Reference No:	2024/62/93322/E
Site Address:	35, Crawshaw Street, Ravensthorpe, Dewsbury, WF13 3ER
Description:	Erection of two storey and single storey rear extension
Recommending Officer:	Jennifer Booth

DECISION – REFUSED

PROPOSED SITE PLAN

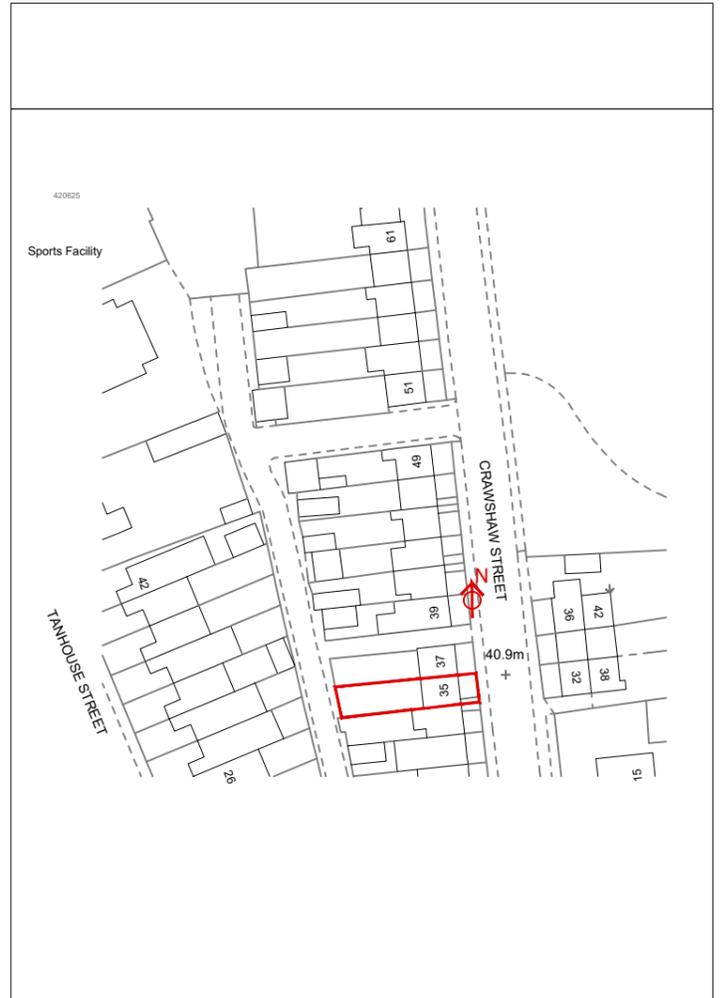
The extension would be constructed along with the shared boundary with the adjoining property with the potential to result in an overbearing impact. However, the ground floor with its projection of 6m has already been agreed through a larger home notification. The first floor is reduced in terms of projection to 3m. However, the first

floor would be along the shared boundary and would have an overbearing and oppressive impact on the bedroom window of the adjoining dwelling having a detrimental impact to the outlook from this window. Having regard to the orientation of the site, whilst the proposal would lead to a degree of overshadowing, it is considered this increase would not be of such significance to warrant refusal in this case.

The proposed extension, by reason of its projection along the shared boundary with the adjoining 33 Crawshaw Street would result in an overbearing oppressive impact on the bedroom window of the adjoining dwelling. To permit the proposals would be contrary to Policy LP24 of the Kirklees Local Plan, KDP1 & KDP2 of the House Extensions & Alterations SPD and Chapter 12 of the National Planning Policy Framework.

1. The proposed extension, by reason of its projection along the shared boundary with the adjoining 33 Crawshaw Street would result in an overbearing and oppressive impact on the bedroom window of the adjoining dwelling which would have a detrimental impact upon the outlook from this opening. To permit the proposals would be contrary to Policy LP24 of the Kirklees Local Plan, KDP1 & KDP2 of the House Extensions & Alterations SPD and policies within Chapter 12 of the National Planning Policy Framework.
